RE: 316 Presumpscot Street

From: Barbara Barhydt [mailto:bab@portlandmaine.gov]
Sent: Tuesday, December 19, 2017 9:37 AM
To: Peter Biegel <pbiegel@landdesignsolutions.com>
Subject: 316 Presumpscot Street

The survey submitted is dated 1994, as you noted in the submission. In looking at the aerials, the survey does not appear to be up to date and does not reflect the additional buildings and pavement that are currently on the site. The site plan does show the buildings, but the site plan is supposed to be based upon a recent survey. To complete the application, an updated survey is needed. When would this be available? **The 1994 survey is provided because that shows the Property Boundary and is sealed by Kevin Cullenberg a licensed land surveyor. As stated in note 4 of the site plan other existing conditions information which was needed was added to the site plan by the design team using a variety of methods such as field observations and measurements, aerial images and additional on the ground surveying by Cullenberg Surveying.**

STANDARD BOUNDARY SURVEY  
**PLAN OF PROPERTY**  
 PRESUMPCOT STREET PORTLAND, MAINE  
 made for  
**TIM O'DONOVAN**  
 30 LEDGEWOOD DRIVE FALMOUTH, MAINE  
 May 4, 1995  
**CULLENBERG LAND SURVEYING**  
 892 OLD DANVILLE ROAD  
 AUBURN, MAINE 04210  
 777-1150

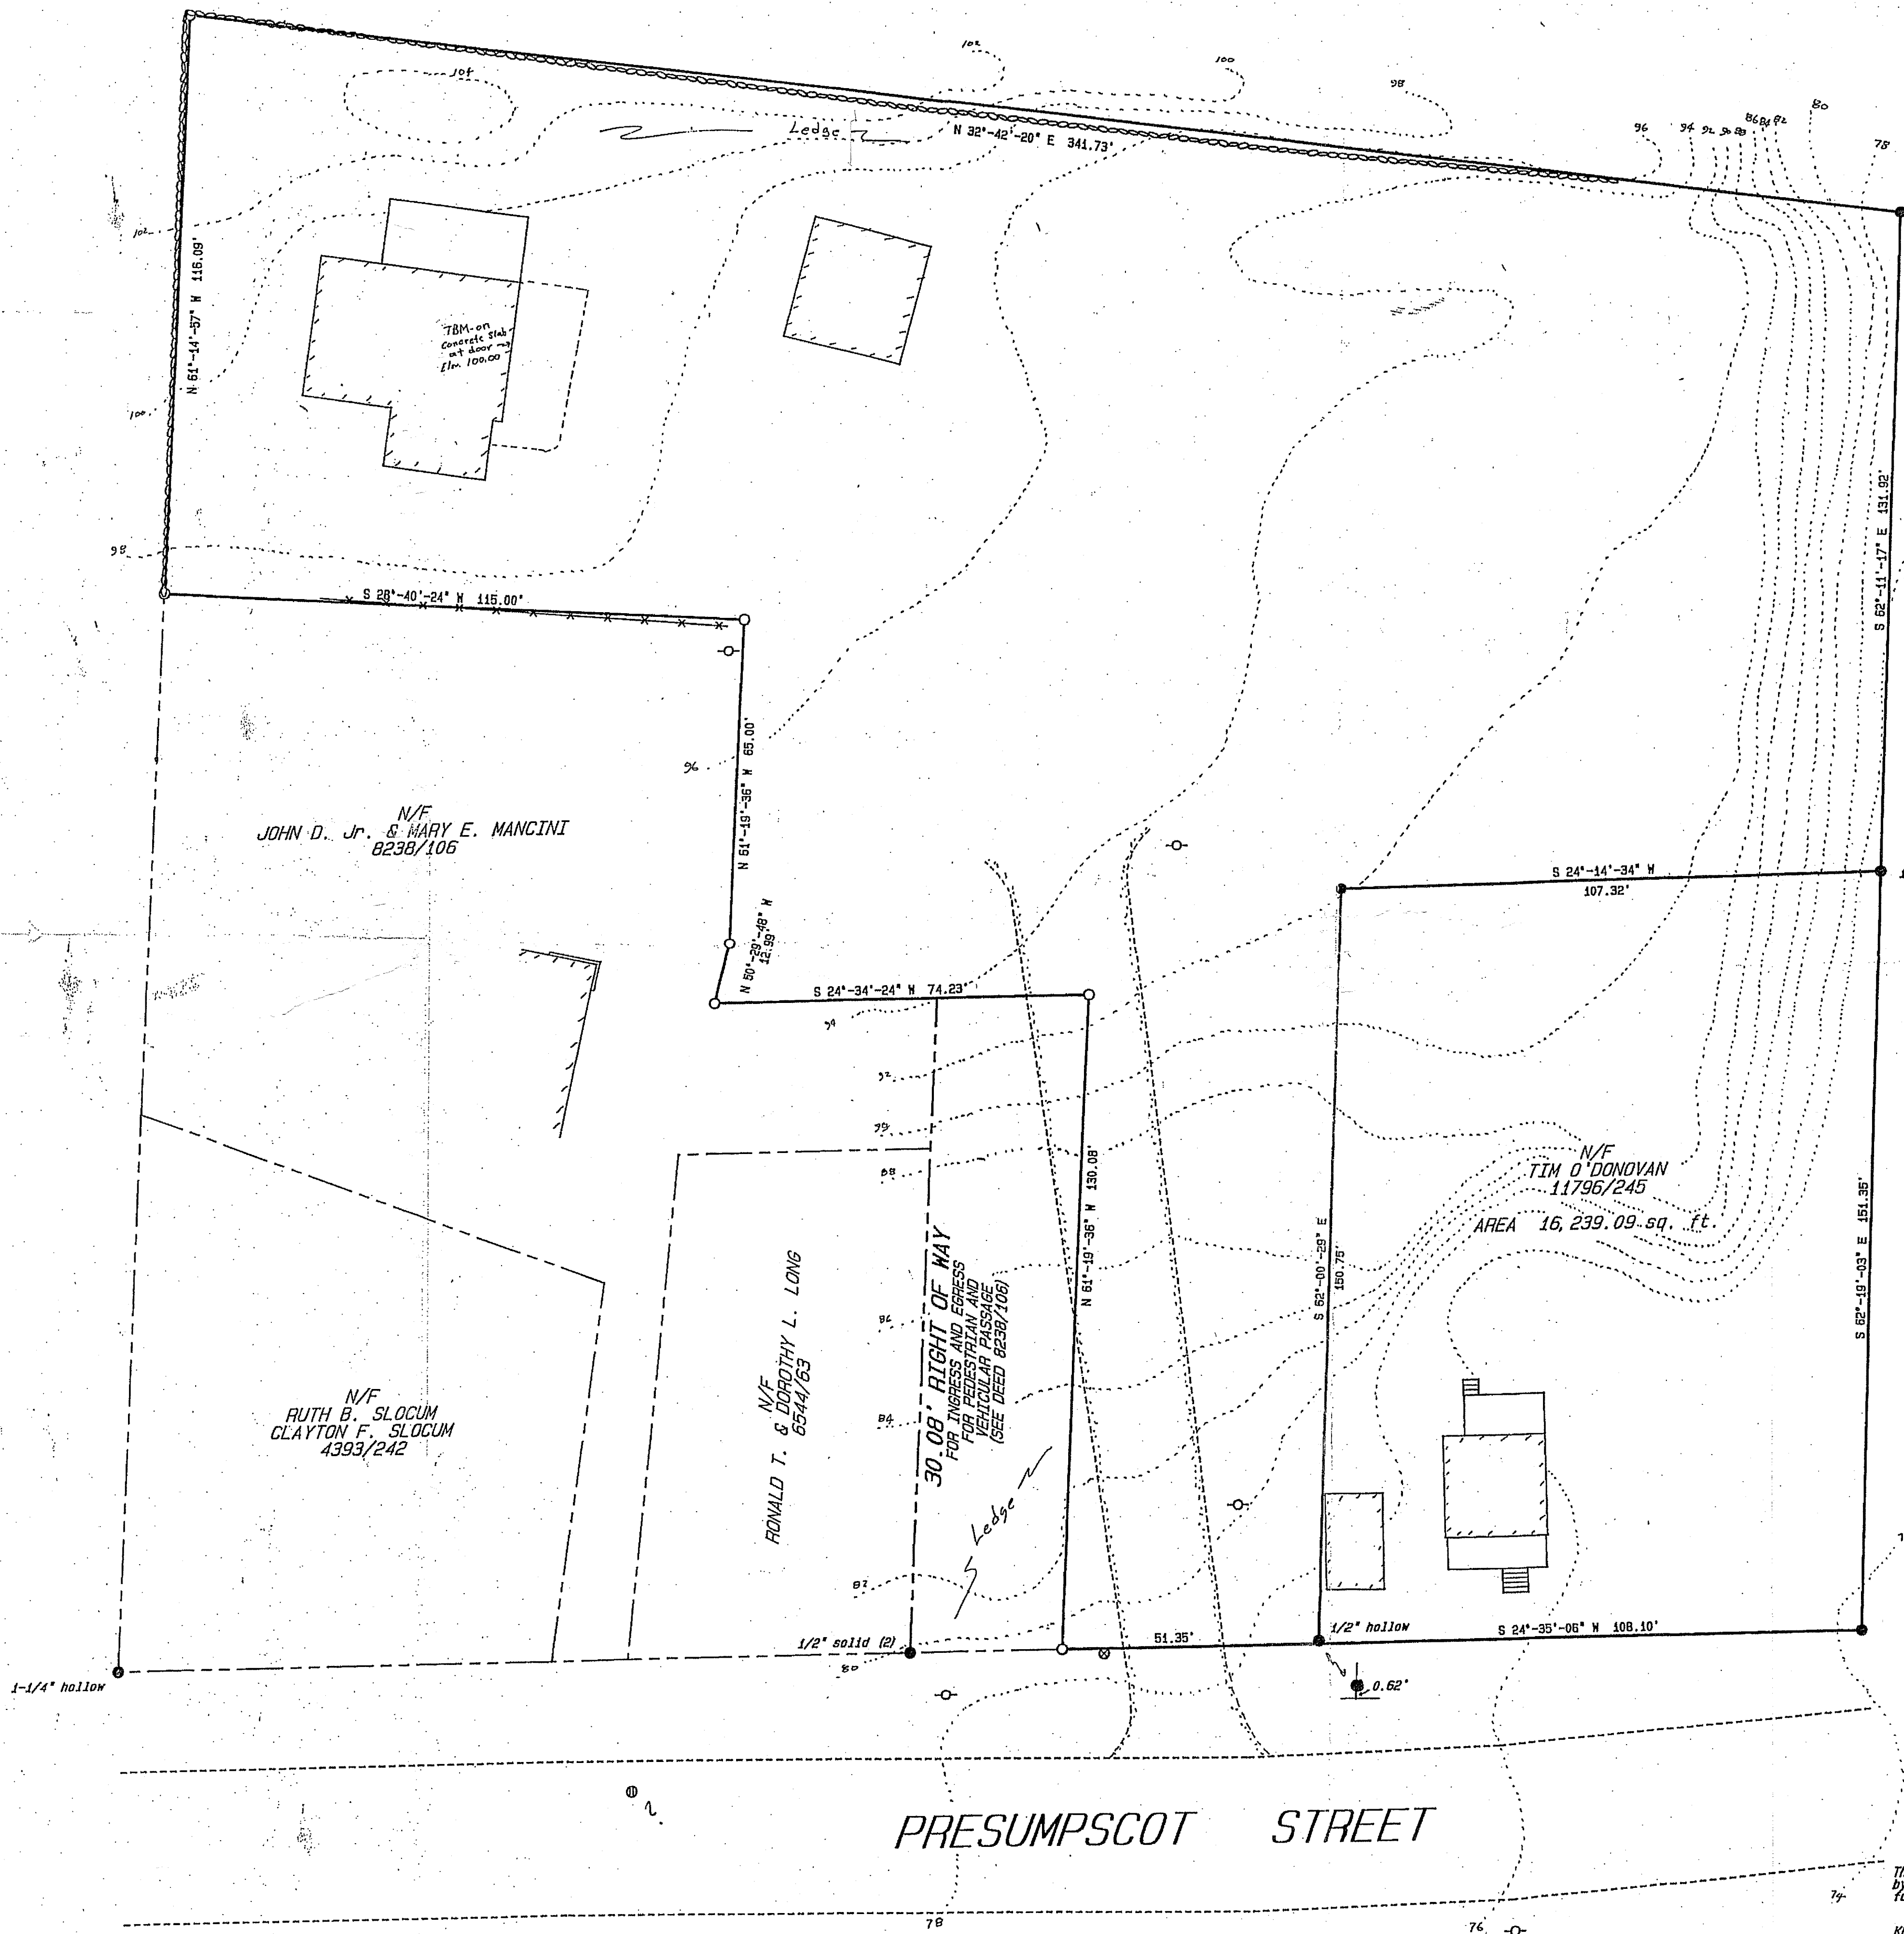
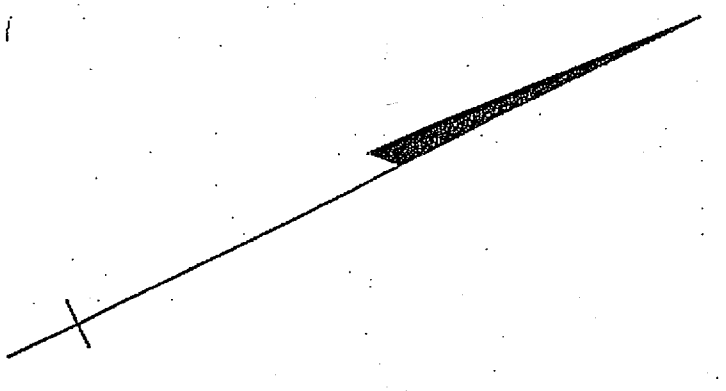
I shared your e-mail and the survey with Keith Gray, Senior Engineer for DPW. He is willing to look at the plans and discuss with the City's surveyors once this is distributed for review. He did ask if the abutting property owner information is up to date on the site plan?

REV.	DATE	STATUS	BY	CHKD.	APPD.	REV.	DATE	STATUS	BY	CHKD.	APPD.
A	12/20/17	SUBMITTED TO THE CITY OF PORTLAND WITH CONSTRUCTION MANAGEMENT PLAN	DEPT.	PBB	PBB

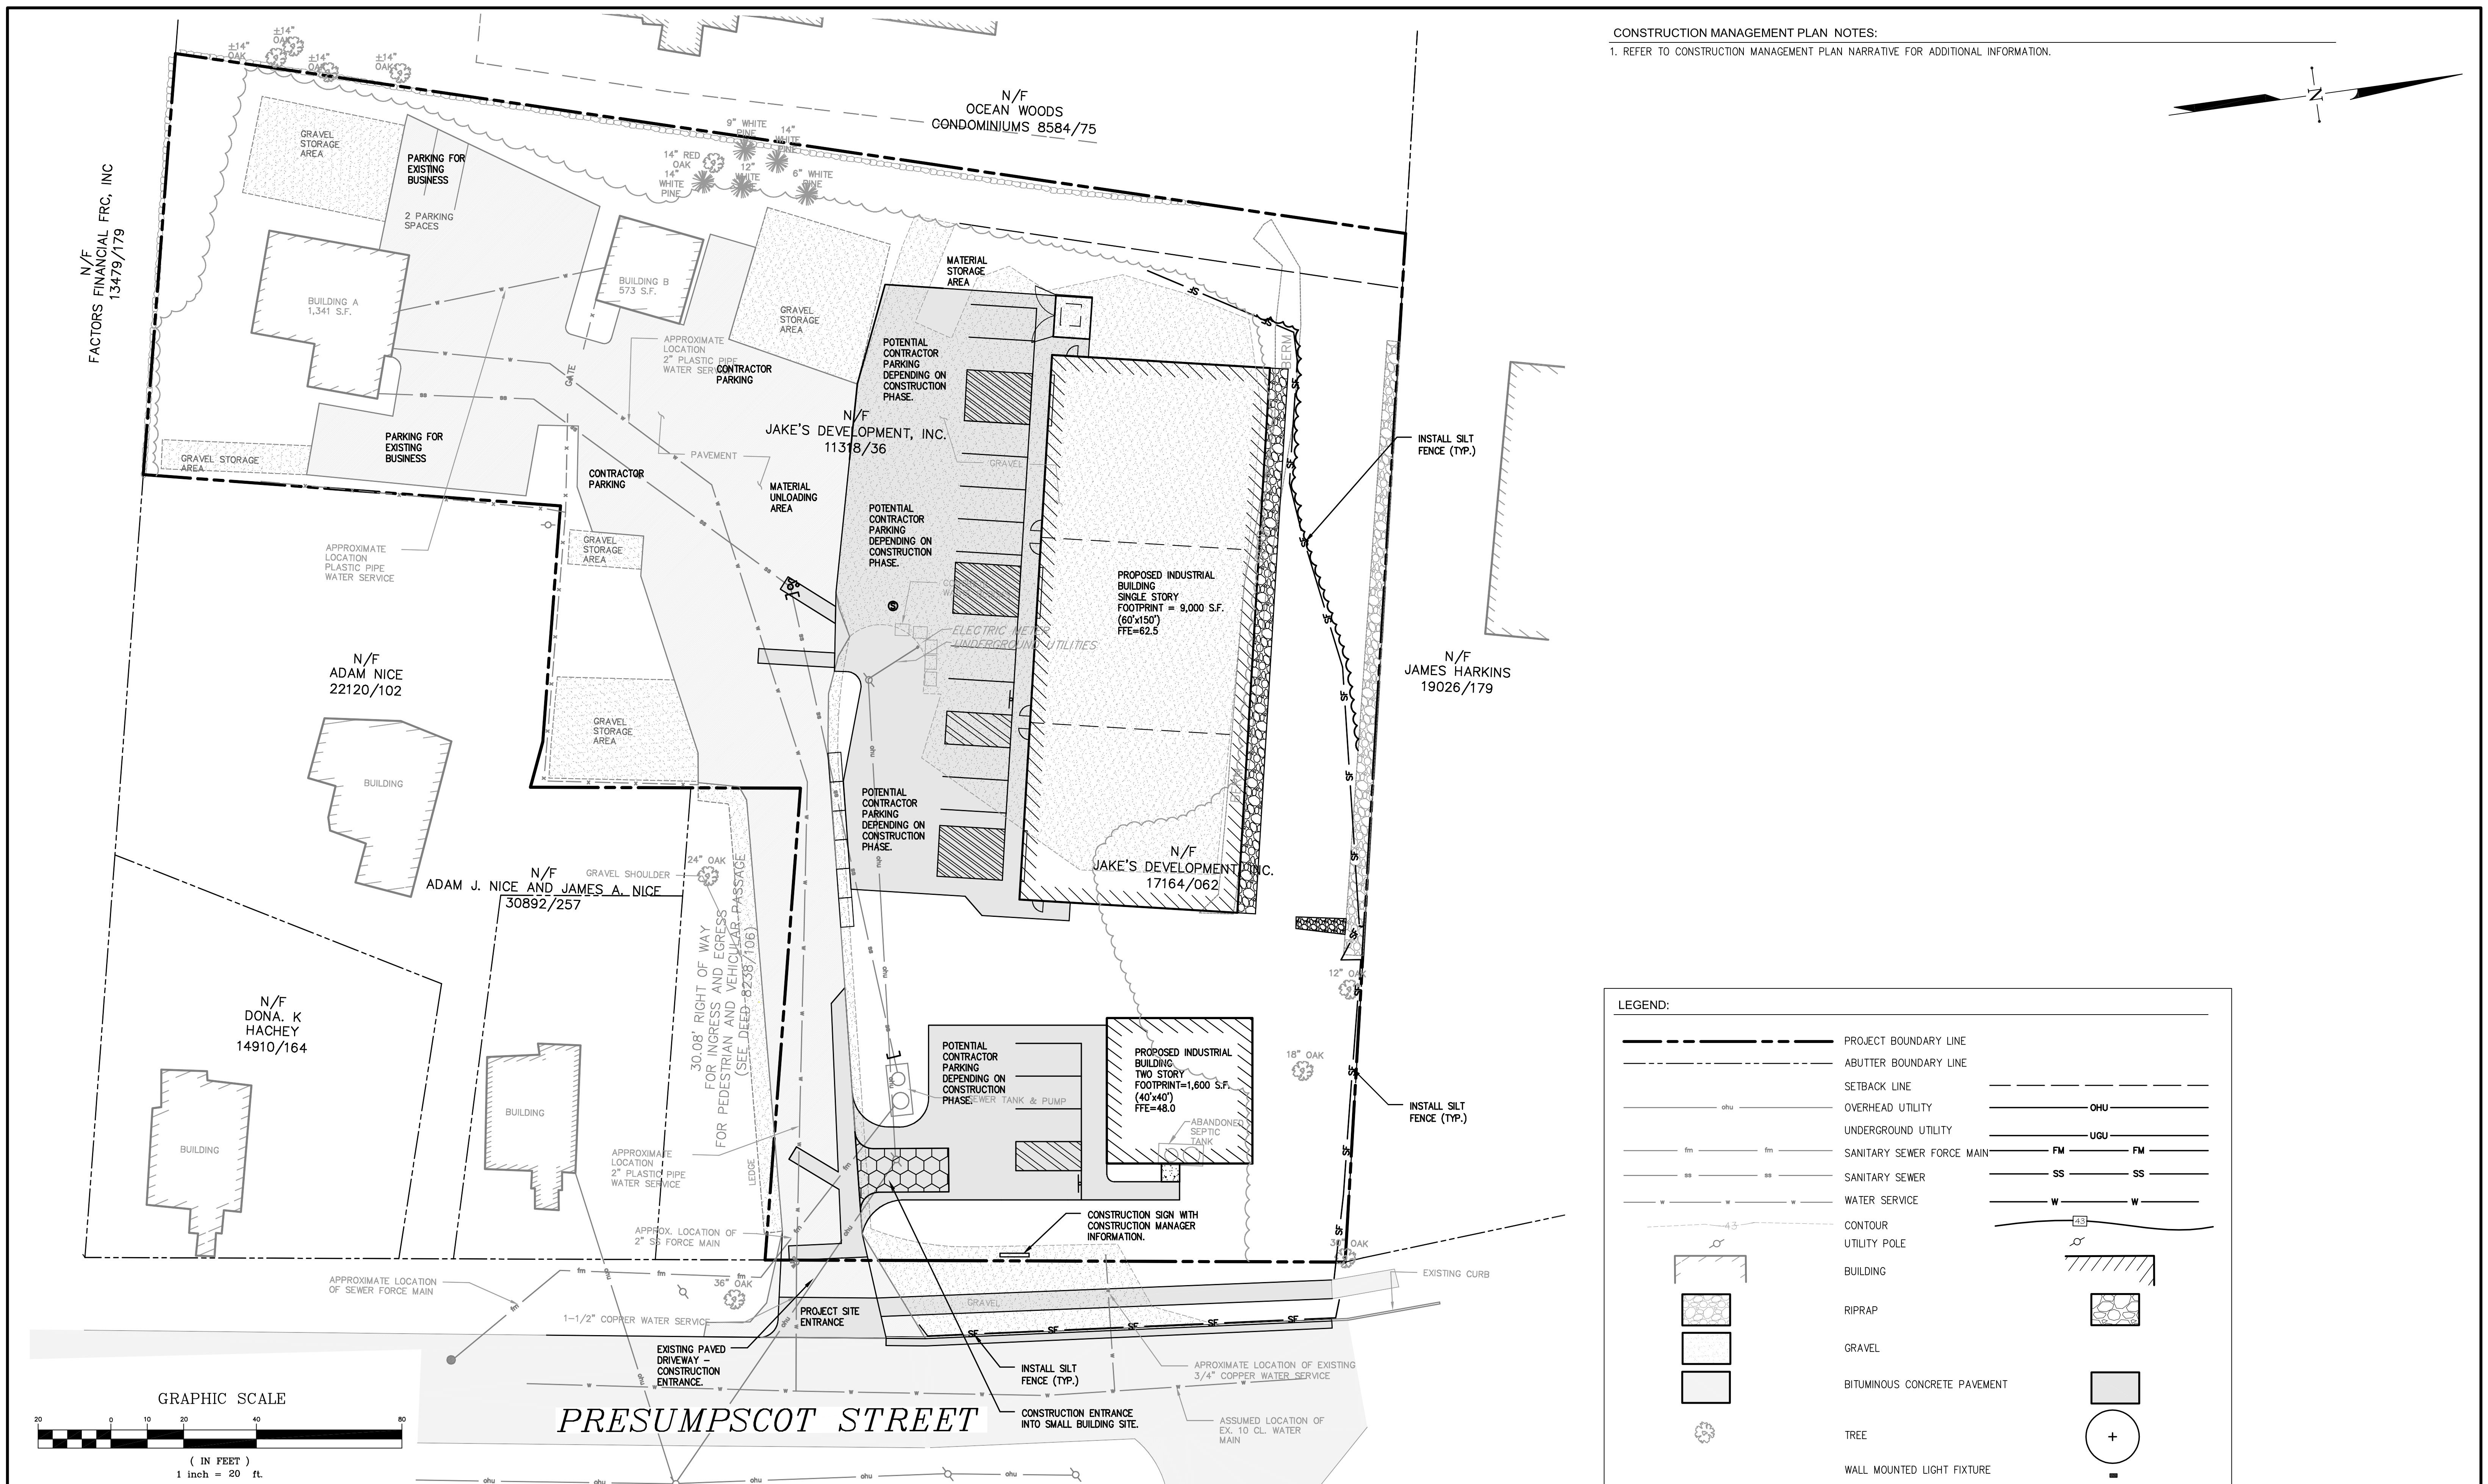
I am attaching the template we are using for construction management plans. Please use this to develop the construction management plan for this project. **I am working on this as we speak and should have it back to you within the next couple of days.**
